West Midlands
Interchange

The West Midlands Rail Freight Interchange Order 201X

Applicant's Post Hearing Submissions (ISH1 – Draft DCO and DCOB 28.2.19) – Document 9.1

ISH1 Agenda Annex 2 - Draft DCO – Structure, Definitions and Articles 1 – 49 (Agenda item 4)

B2 & B3 - Proposed Road Bridge, Over Existing West Coast Mainline and SI Group Access Road (Elevation E2)
(Scale 1:100)

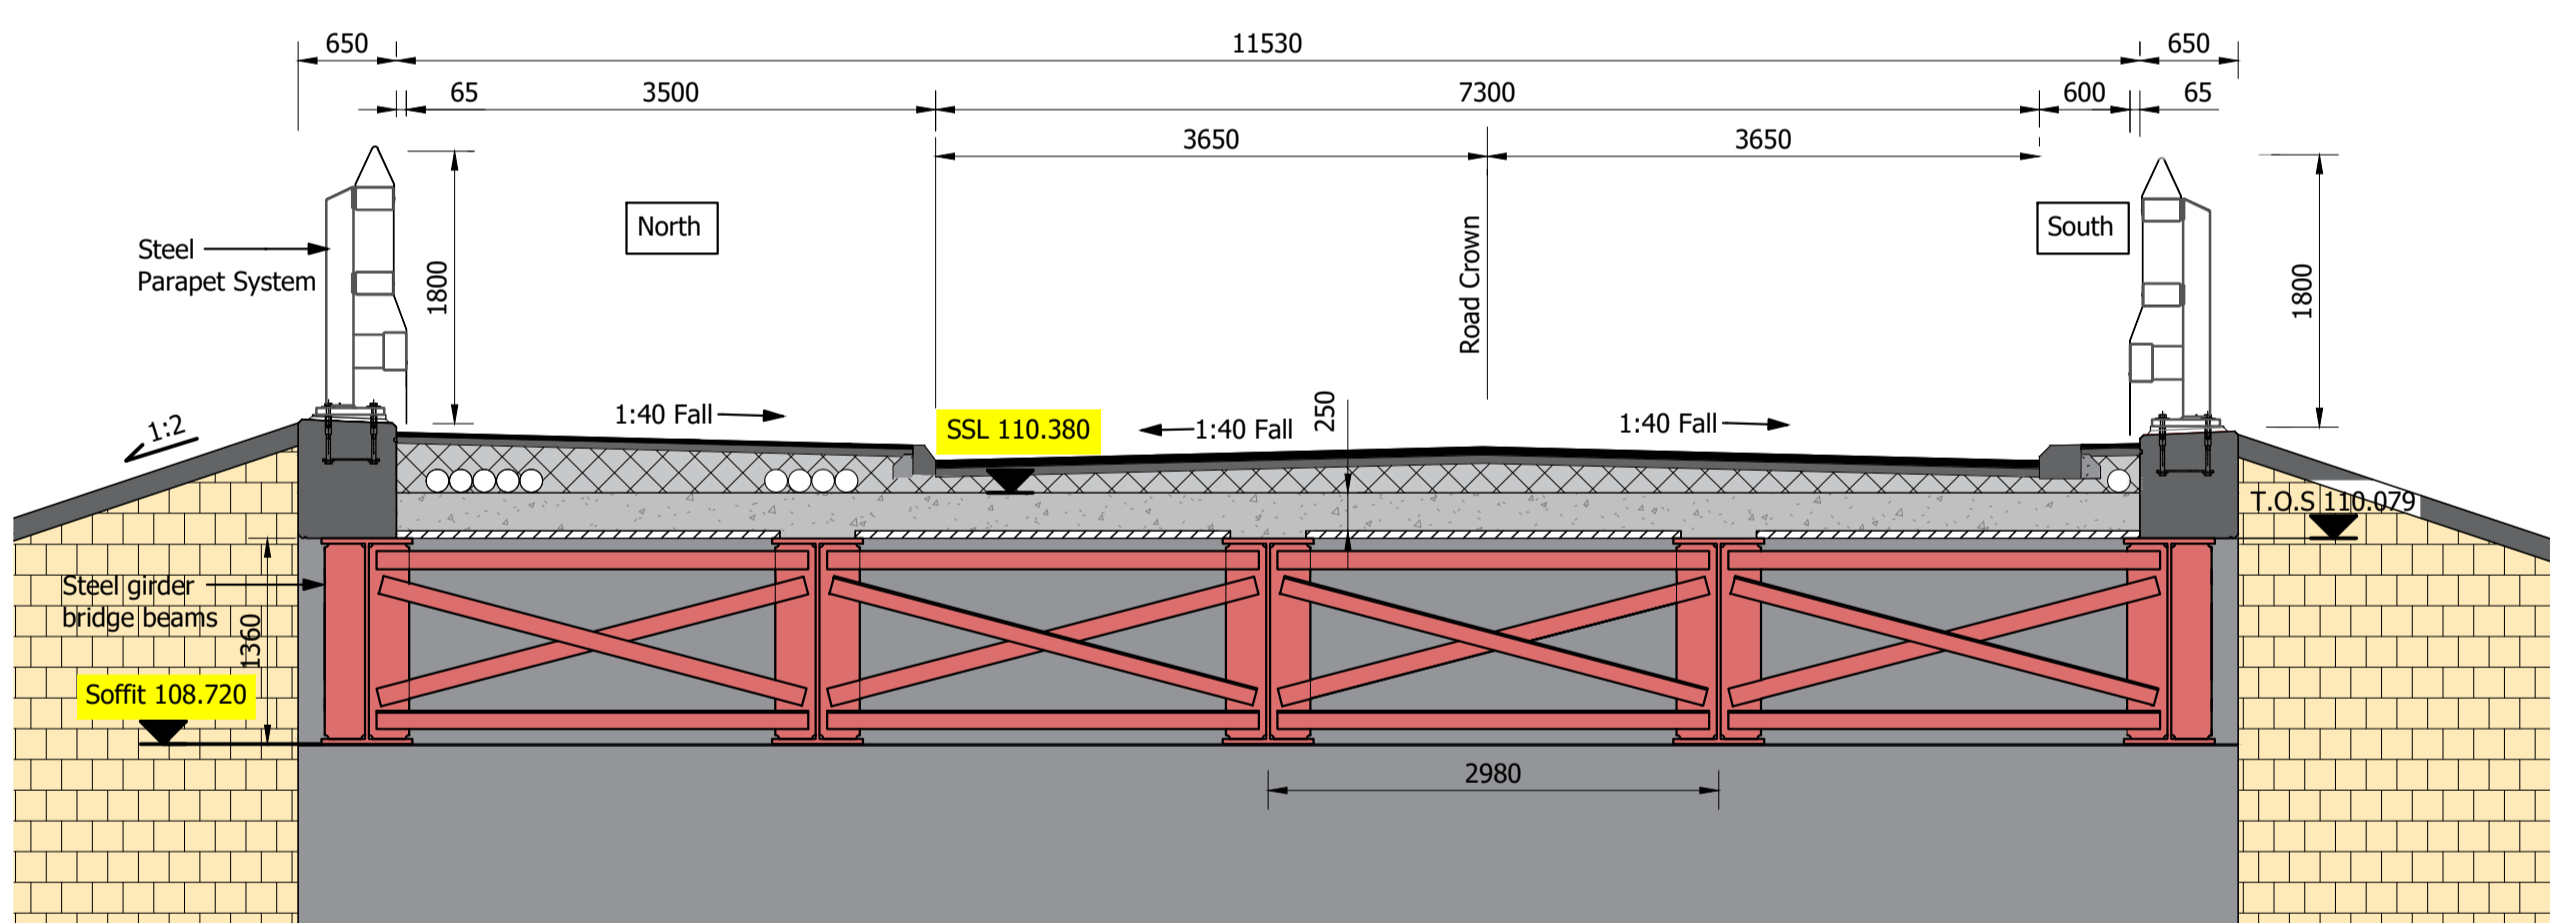
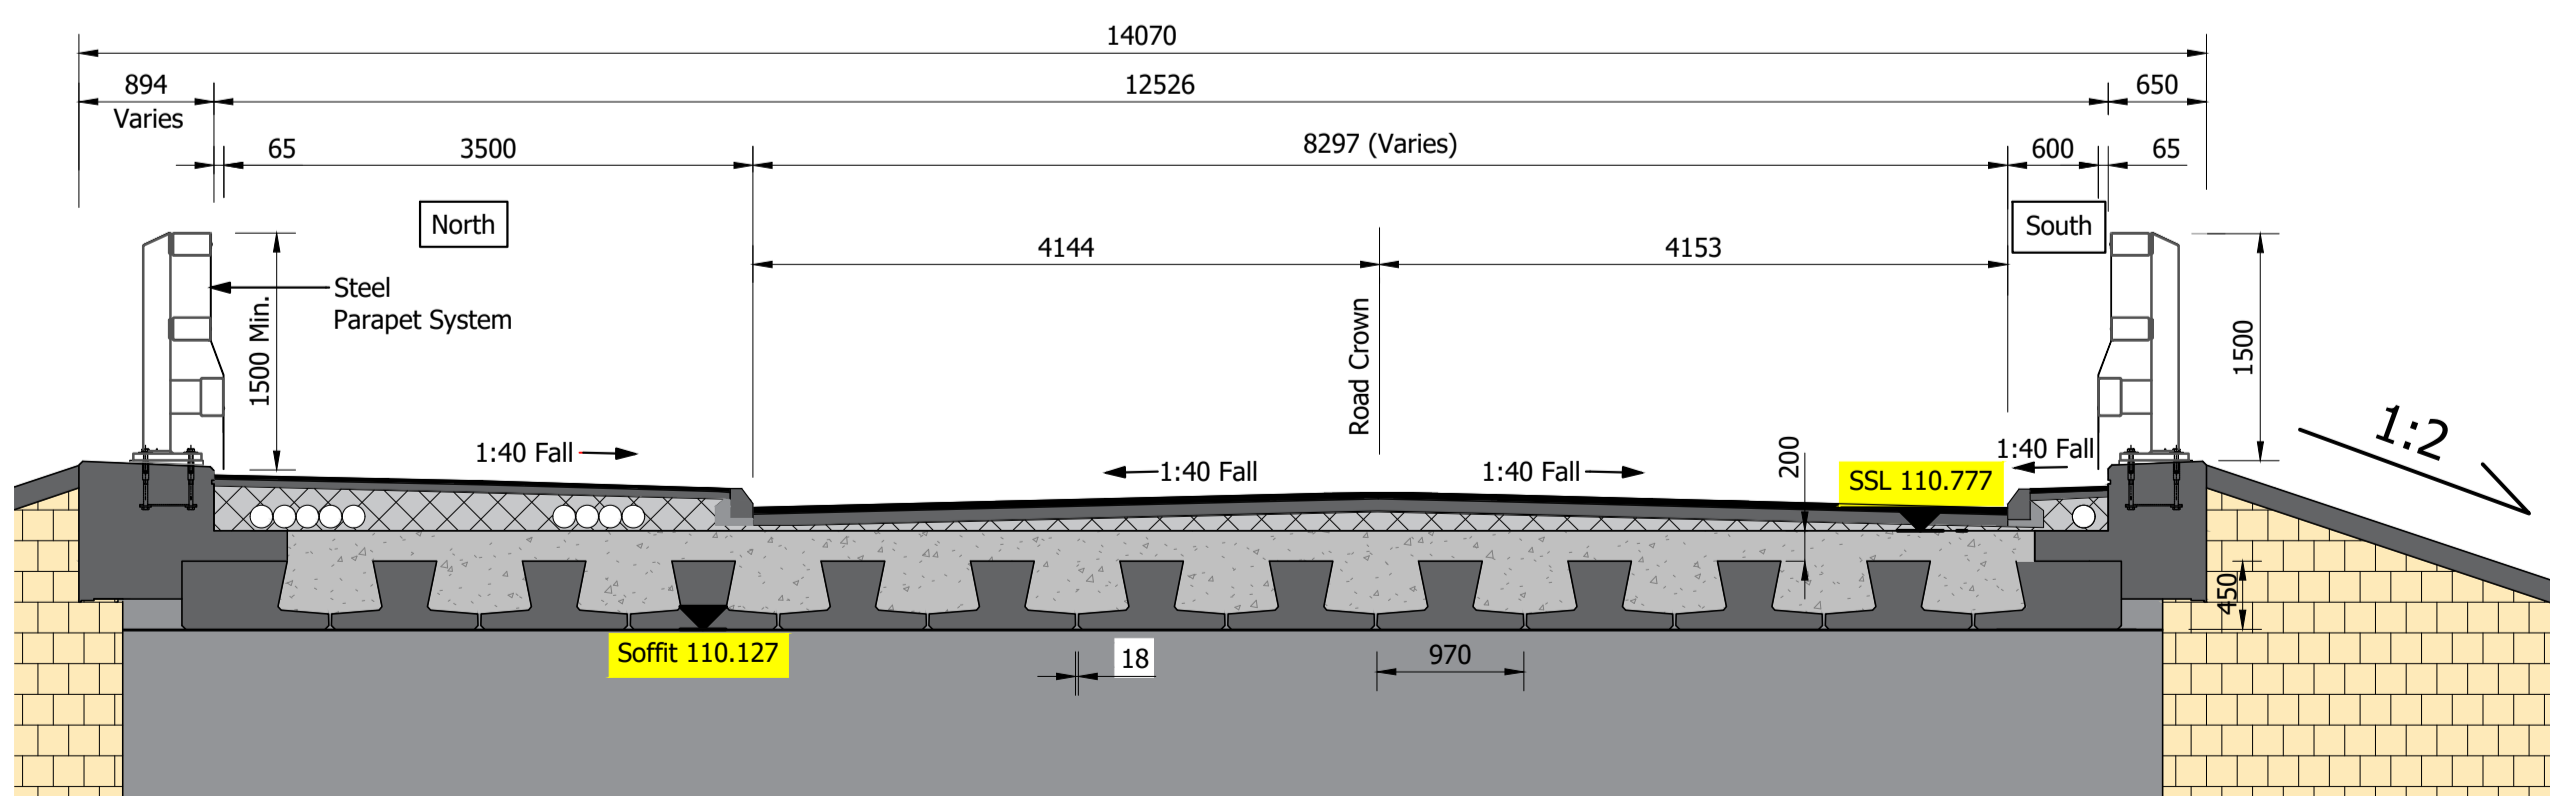
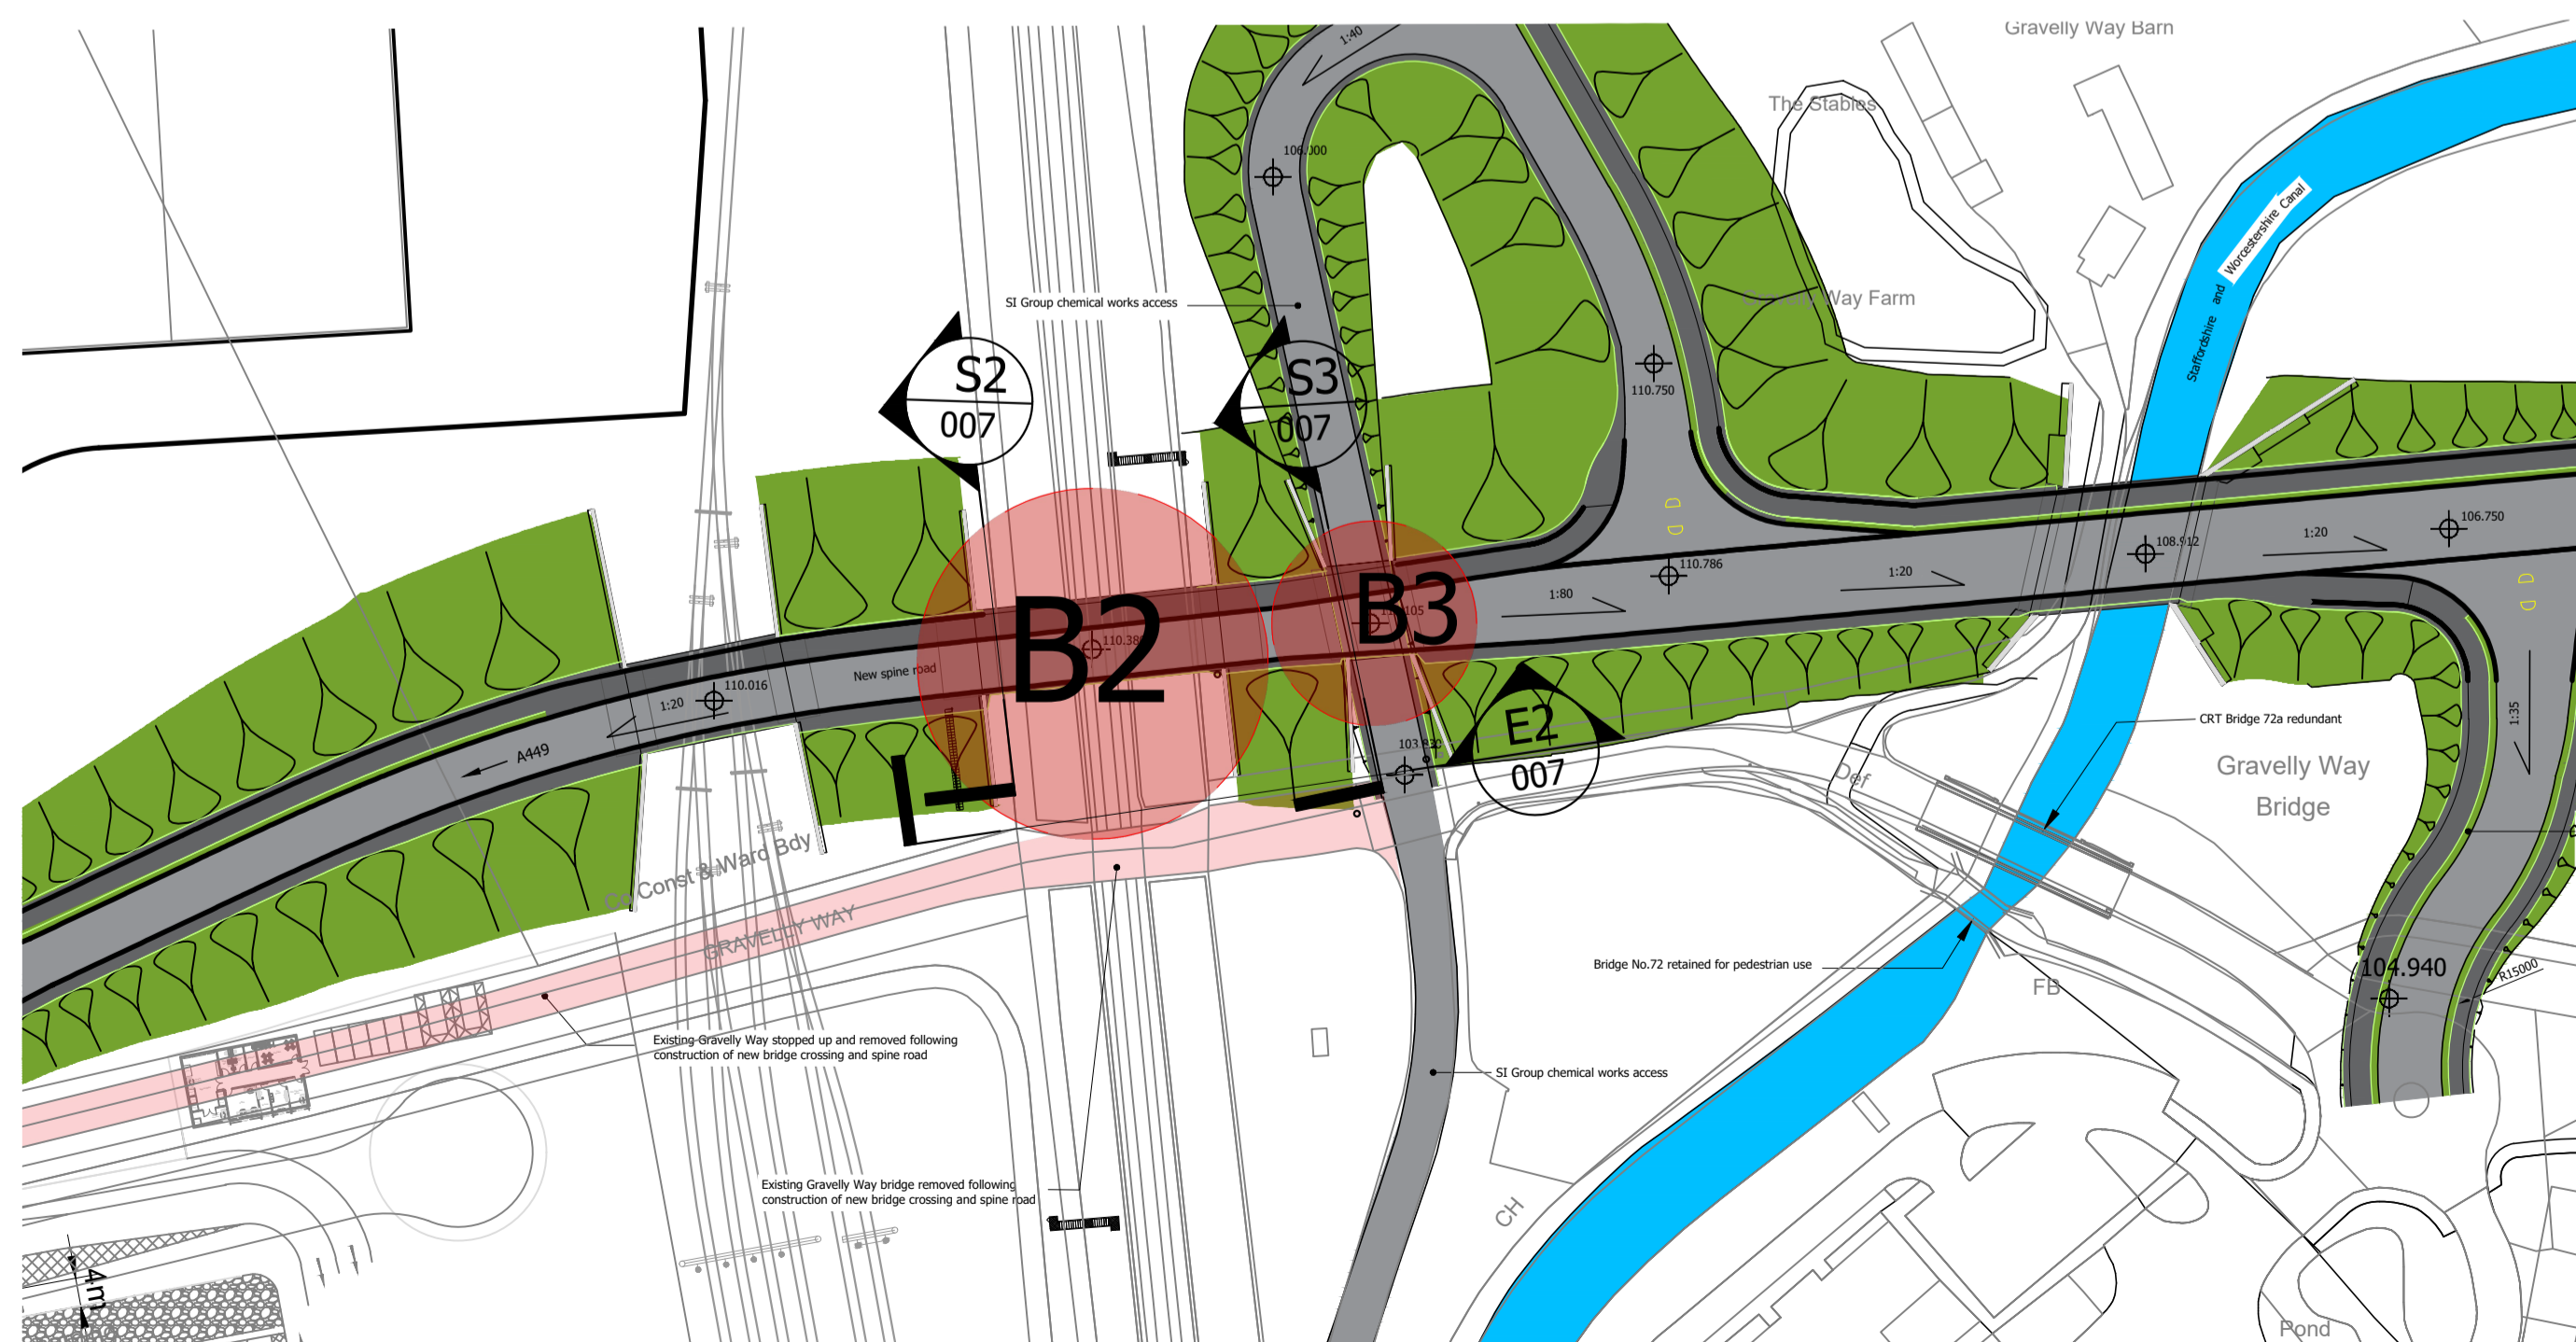
1.10	A4	Applicant	<p>i) How would Clause (b) operate alongside the annotations on the Bridge Plans which indicate detailed levels for the underside, deck and other key elements of the proposed bridges and set minimum clearance levels for the underside of bridges?</p> <p>ii) Would there be a risk that the flexibility provided by Clause (b) might operate in tandem with that provided by Clause (c) (i.e. in relation to a bridge over part of the railway works) to result in an upwards deviation in the level of such a bridge by 3 metres?</p>	<p>i) It is intended that the exact detail of the bridge design is to be approved before construction (requirement 3 will be amended to provide for that explicitly). The ExA will note that some of these annotations on the Bridge Plans refer to approximate distances. The maximum limits of deviation are required to ensure that the DCO allows for tolerance to accommodate normal variations required when construction details are known.</p> <p>ii) The Applicant does not consider that there is a risk of this, but will consider whether the wording of sub-paragraphs (b) and (c) might be suitably amended to alleviate any concerns. The railway works mentioned in sub-paragraph (c) specifically relate to Works 1 and 2, whereas the construction of the bridges is contained in Works 4. However, the Applicant understands the potential for confusion and suggests that article 4(b) is amended to refer to "bridges" rather than "bridge</p>

Q Ref	Part of DCO	Directed to	Question/ comment	Applicant's Response
			<p>iii) Has the full degree of flexibility provided for in A4 been assessed in the ES on a worst case basis?</p>	<p>works”, since the term “bridges” is defined with reference to the Bridge Plans.</p> <p>iii) The parameter plans make reference to the works plans and these, along with the stated variations in Article 4, have been considered in the ES where effects have been considered on a worst case basis.</p> <p>The Applicant clarified at the ISH that A4 does not permit development beyond the parameters and referred to other DCOs which contain similar provisions, as mentioned in the Explanatory Memorandum. The Applicant does, however, acknowledge that there needs to be a clearer relationship between the drafting of A4 and the Bridge Plans, specifically which measurements on the Bridge Plans the tolerance applies to.</p>
